REPORT UPDATE

Application No: A/30/26/PL

REF NO: A/30/26/PL

PROPOSAL: Demolition of existing open sided structures and erection of retail canopies and restaurant lobby. This application is in CIL Zone 3 (Zero Rated) as other development.

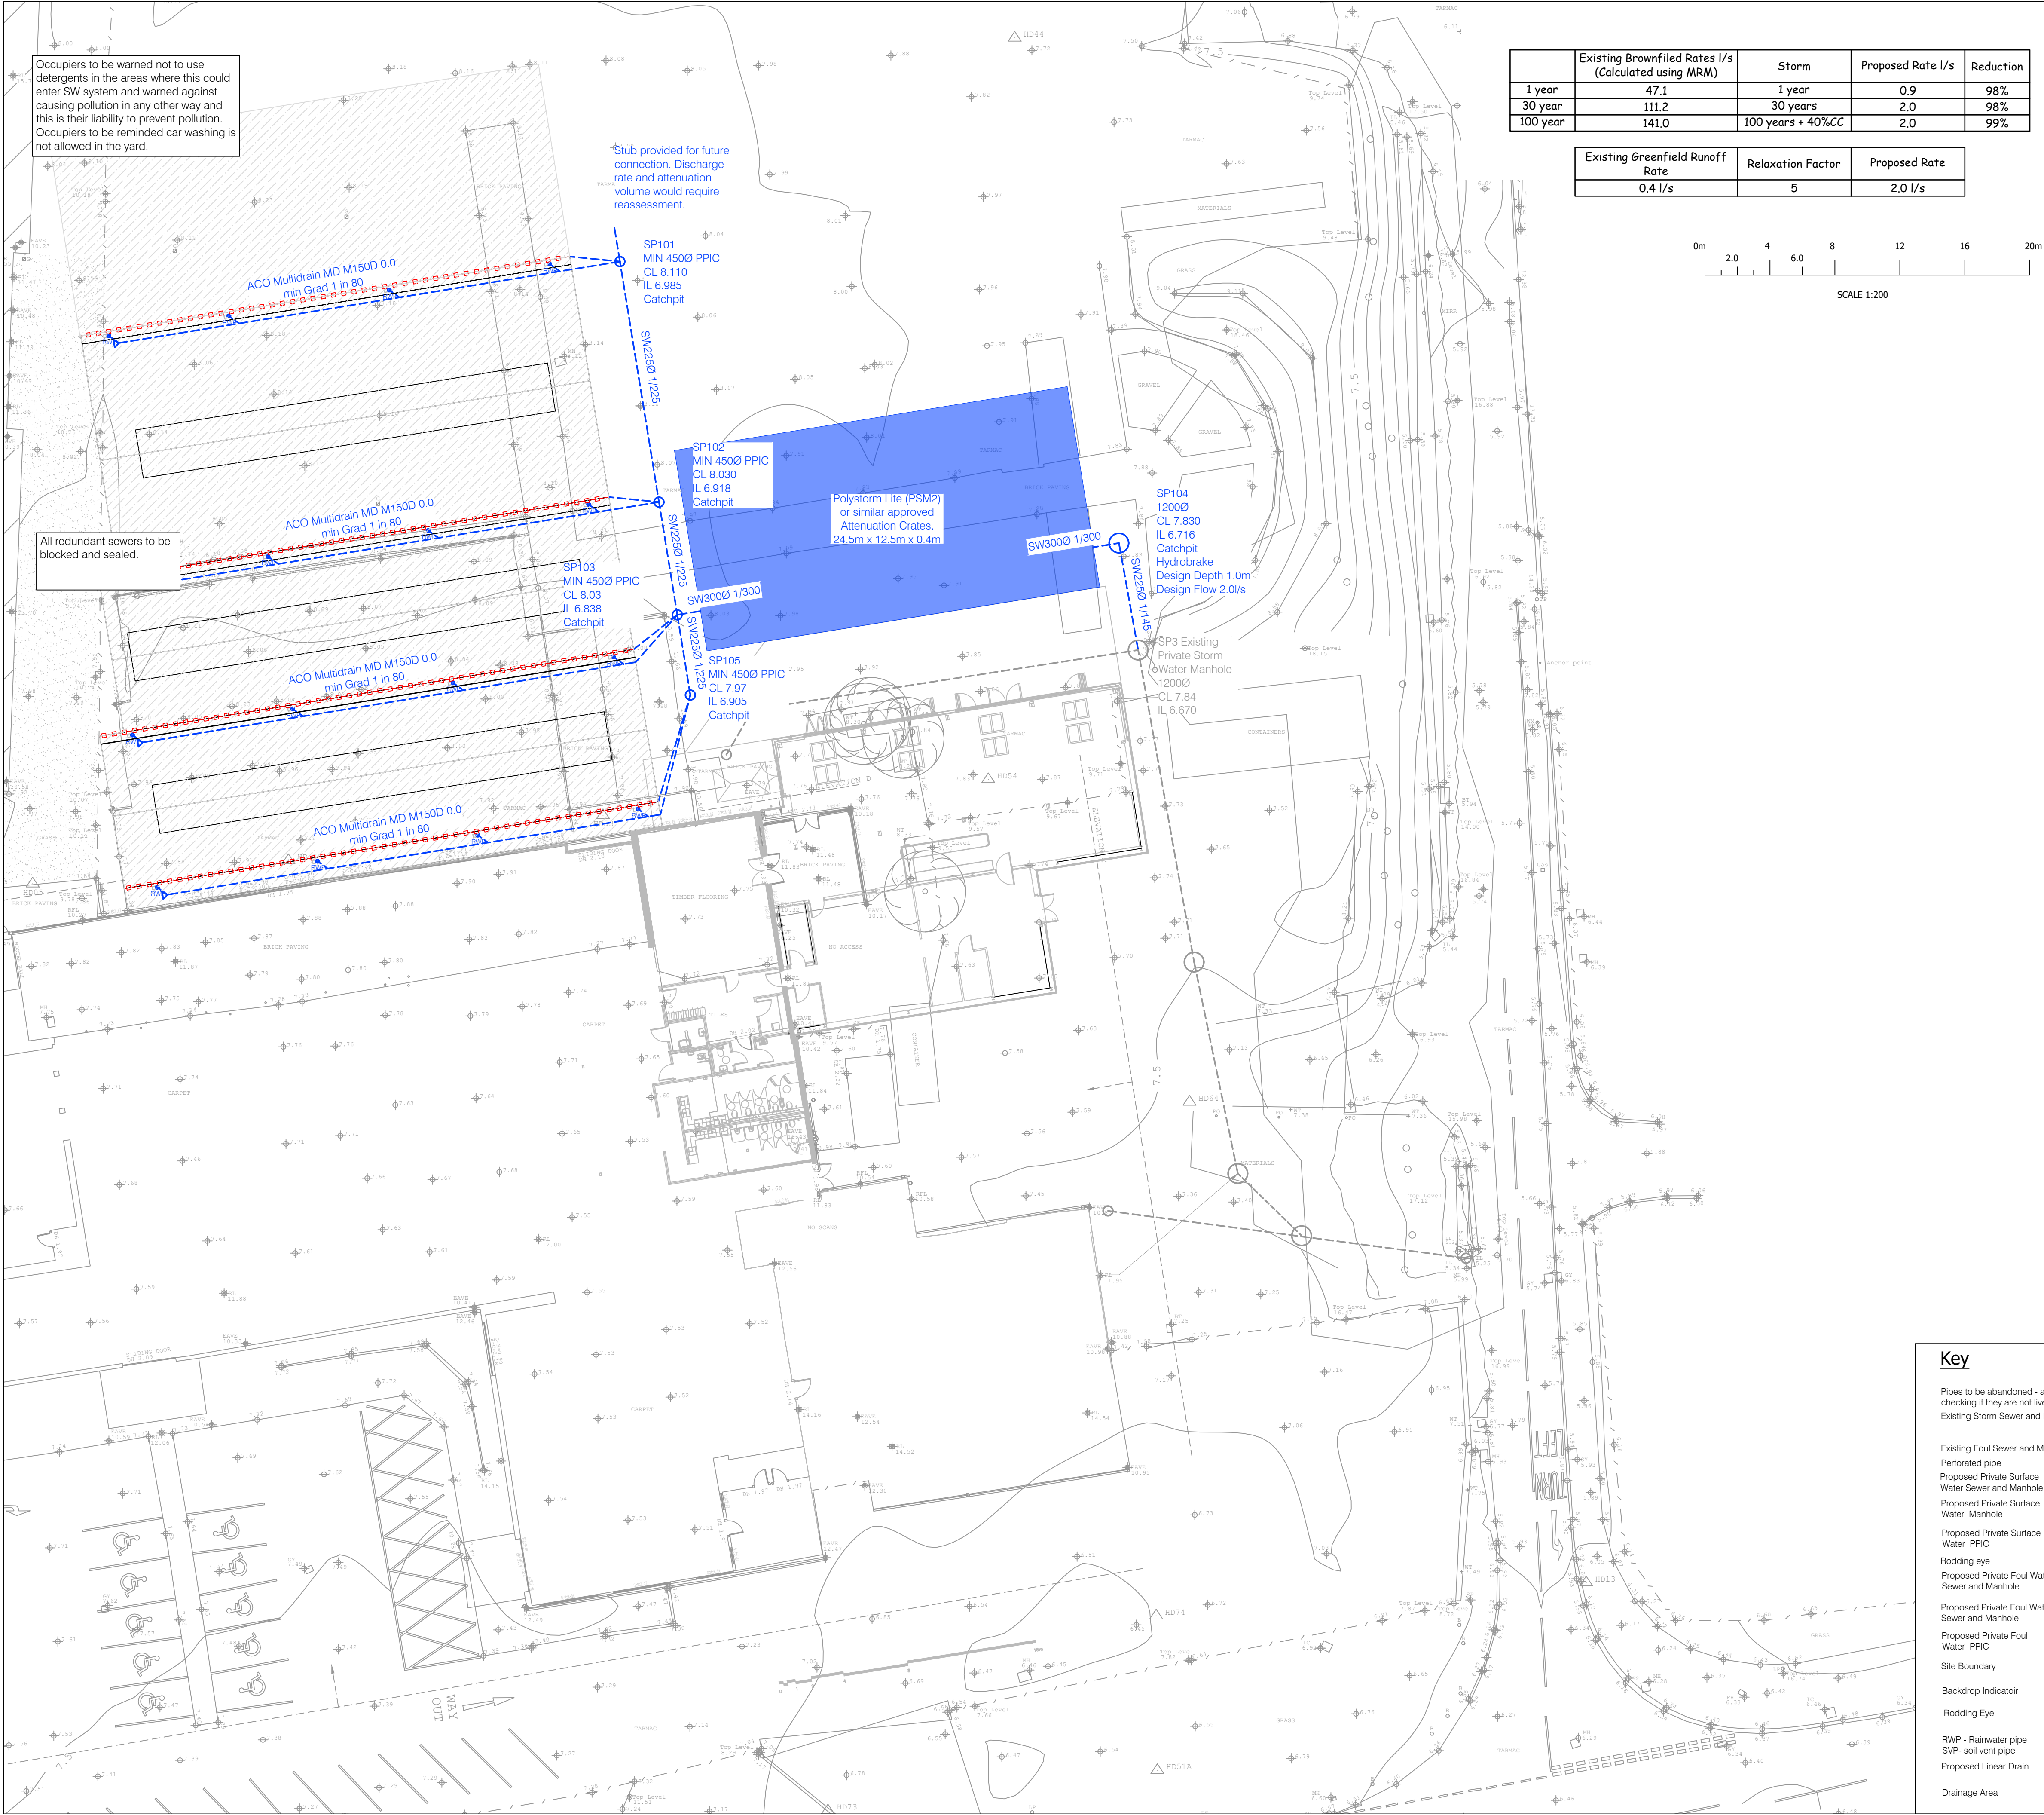
- The drainage layout currently does not show the outfall position.

- A Drainage Statement has not been submitted and the submitted Drainage Layout drawing provides insufficient information and does not meet local standards for assessing sustainable drainage.

- Site is not at significant risk of flooding from external sources, a Flood Risk Assessment is not required.
- The proposed runoff destination is to a restricted piped outlet connecting to the existing drainage system but the downstream outfall and connectivity are unclear.

- Interception drainage is not incorporated into the design and no justification for its omission is provided. The scheme does not comply with National Standards for SuDS Standard 2 - an objection is raised.

- The drainage design includes flow restriction and below ground attenuation but no calculations have been provided to demonstrate compliance with greenfield runoff rates. Management of extreme rainfall events has not been adequately addressed and the proposal does not comply with National Standards for SuDS Standard 3.

- No water quality mitigation measures are shown and no assessment has been undertaken using the Simple Index Approach or similar methodology. An assessed including mitigation is required.

- The drainage plan shows a sewer crossing the site which does not appear on SW records, further assessment is required to confirm the sewer's location ownership and potential constraints on the proposed layout.
